Ecology request that Kittitas County consider these late comments for the Mitchell Short Subdivision SP-16-00001. The original letter is in the mail.

Re: SP-16-00001

SUBJECT: Mitchell Short Plat SP-16-0001

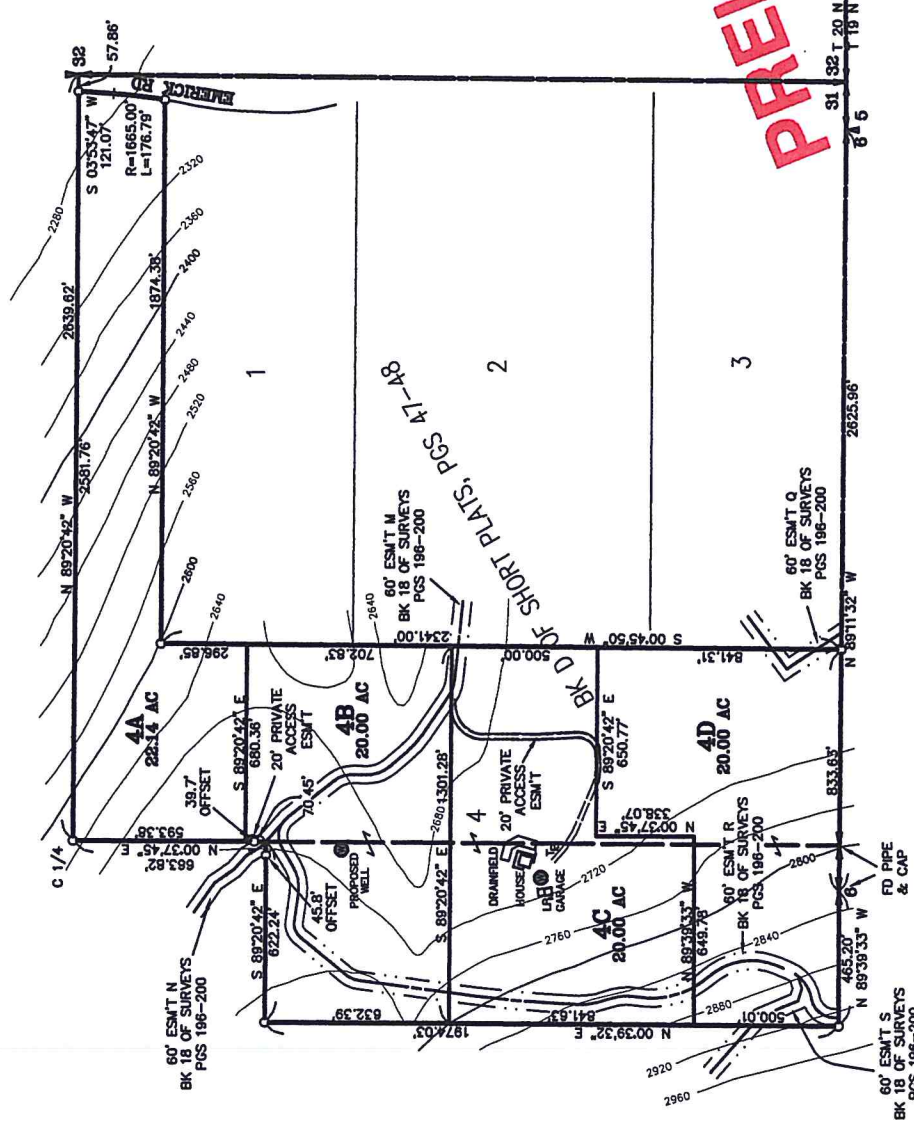
The result of our review is that there are likely to be wetland areas that are associated with the type 9 stream system that flows through the parcel, which is located primarily within proposed parcel 4B. The submitted critical areas checklist states that there are no wetlands on site. Was the site surveyed by a professional wetland scientist?

Ecology recommends that before any development (residences and other necessary infrastructure to support the residential development on site such as roads, utilities, septic, wells, etc.) occurs within these proposed parcels, that the development footprint and buffer areas are reviewed by a wetland professional to assure that wetlands are not directly or indirectly impacted. These proposed lots are of such large size that it should be easy for applicants to assure that construction clearing, wells, septic systems and roads are not placed within wetlands or within their required buffer areas.

1. Transportation Concurrency: Applicant needs to submit their application for Transportation Concurrency to the Department of Public Works.
2. 20' Private Access Easement: The intent of this access easement needs to be specific to lot 4C. Lot 4D will need to come directly off of the 60' Easement Q of Bk 18 pgs 196-200. If the applicant chooses to make the private access easement a shared easement, the easement will need to meet the joint use access requirements.

- g. 20' Private Access Easement: The intent of this access easement needs to be specific for lot 4C. Lot 4D will need to come directly off of the 60' Easement Q of Bk 18 pgs 196-200. If the applicant chooses to make the private access easement a shared easement, the easement will need to meet the joint use access requirements Any further subdivision or lots to be served by proposed access may result in further access requirements.
